**Consultation Response from: KC Environmental Health (Pollution & Noise Control)**

**2025/93343 - Unit 13 and 14, Shaw Park, Silver Street, Moldgreen, HD5 9AF**

**Use of units 13 and 14 as brand-approved accident repair centre and installation of two industry standard spray booths within the existing building**

**Date Responded:**  
**Monday, 01 June 2026**

**Title**  
Figure 2 - Proposed Layout and Location of Exhausts

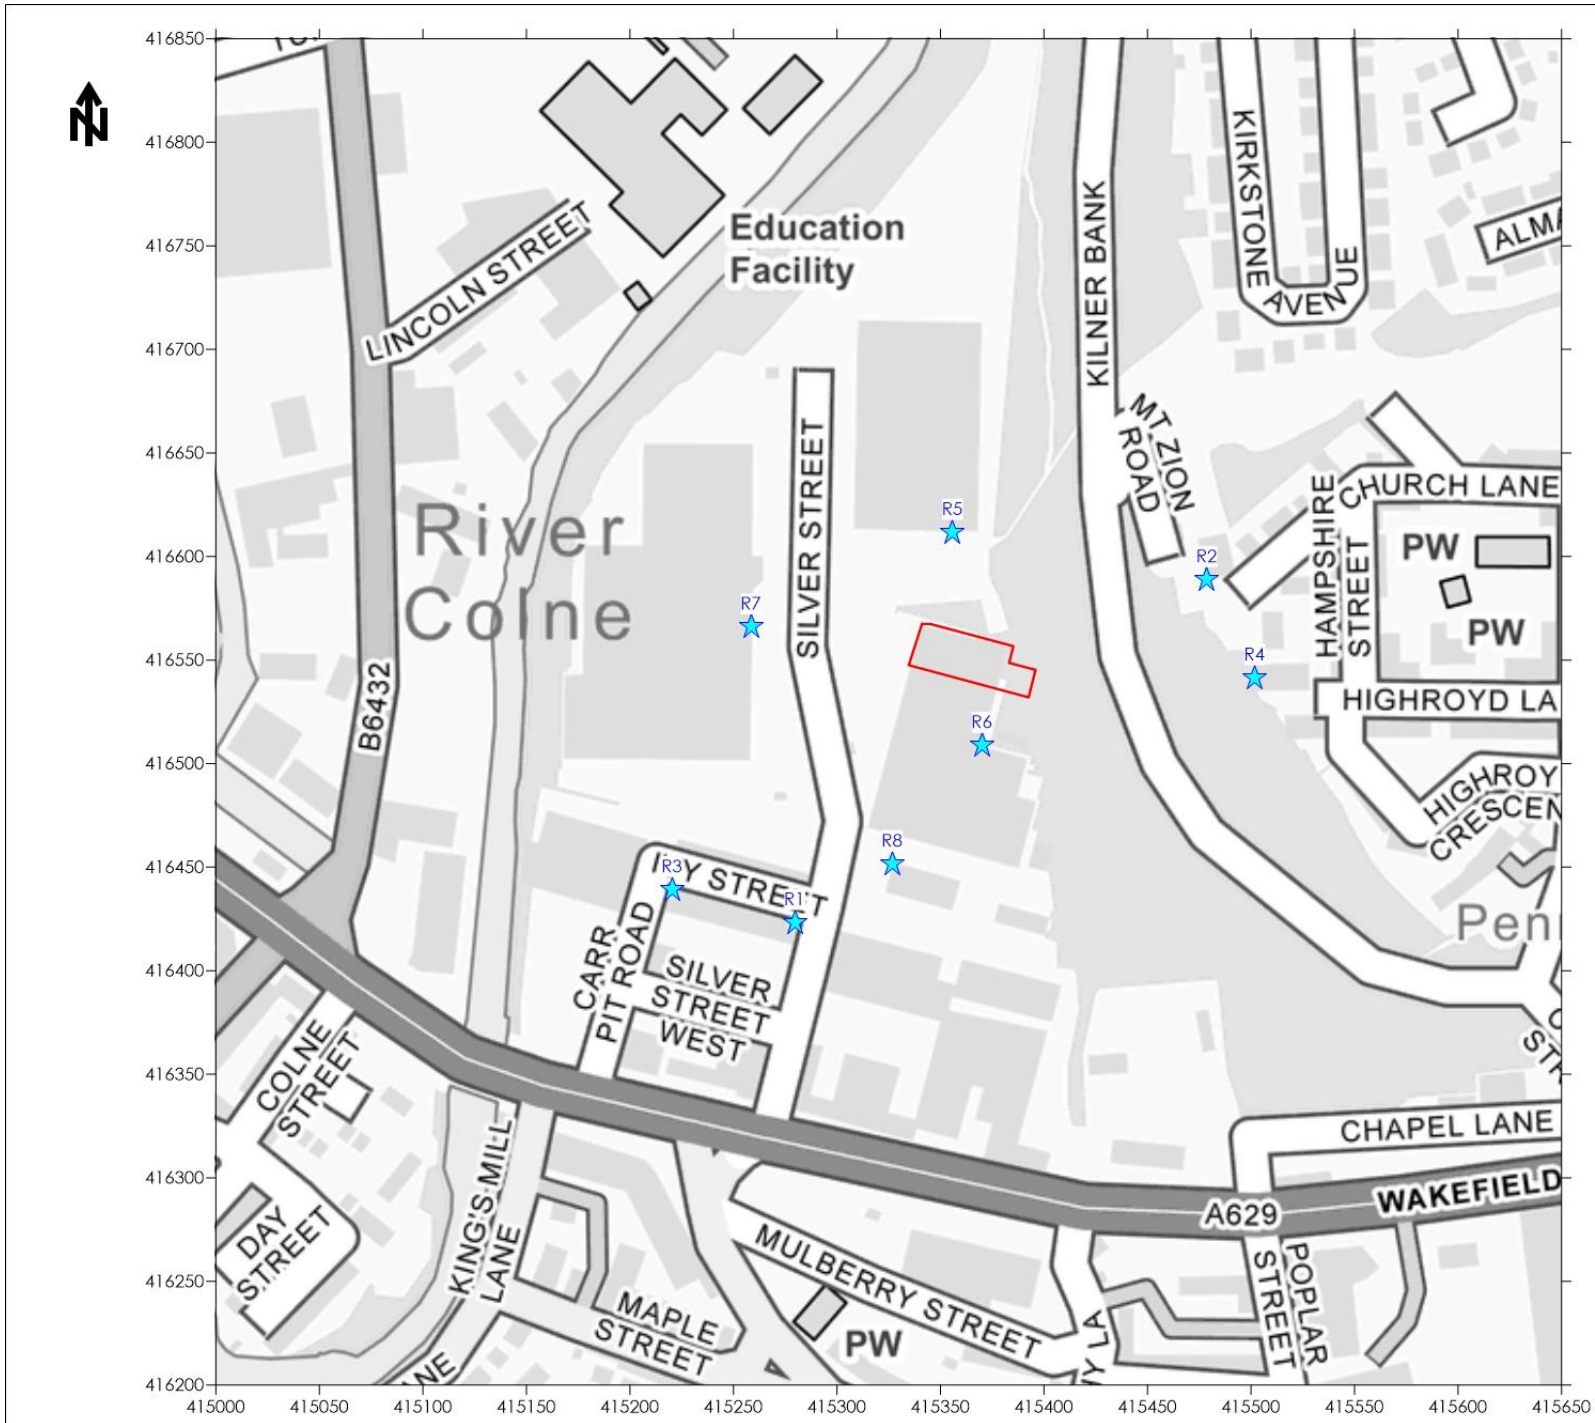
- Paint spraying will occur within the spray booths only and not within the main workshop.
- The stacks associated with the spray booths will discharge on the eastern side of the building at heights of 2.00m and 2.40m above ridge height.

The applicant will need to implement these odour mitigation measures and submit details of the same including service and maintenance plans to the local planning authority to demonstrate how odours will be controlled throughout the lifetime of the proposed plant – to protect the amenity of the nearby odour sensitive receptors.

Figure 2: Site Location Measurement Pictures

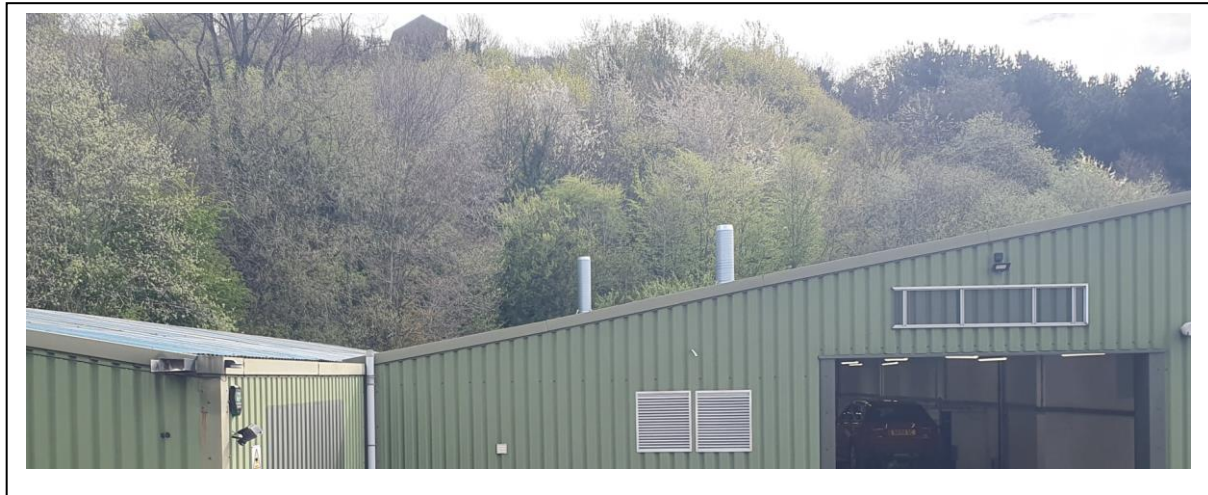
The report presents the findings of a 24hr environmental noise survey undertaken on the 14<sup>th</sup>-15<sup>th</sup> April 2026. The baseline environmental noise survey measurement position (MP1) “was positioned to the northeast site boundary at a height of approximately 2 metres”. This was “deemed representative of sound levels at ‘NSR 1’ during the typical operational periods of the development”. However, the nearest noise sensitive receptor is 100m away from the Shaw Park industrial estate, and therefore, any noise levels measured at MP1 on site

NSR1 is 100m away from these noise sources and therefore a measurement position on site cannot be *“deemed representative of sound levels at ‘NSR 1’* for use within calculations without distance attenuating these measured operational noise levels. Environmental Health do not consider it appropriate to use measured on site noise levels as representative of noise levels at NSR1 – NSR1 is located 100m away in a residential setting separated by vegetation.

We do not consider the submitted noise assessment using this flawed methodology to be acceptable. Baseline noise levels will require revising and the BS4142 assessment repeating with the corrected NSR background sound level – either by:

1. Using a distance attenuated calculated noise level reducing the on-site operational noise levels measured *“to the northeast site boundary at a height of approximately 2 metres”* by the appropriate separating distance, or by
2. Direct measurement at a representative residential noise sensitive receptor location.
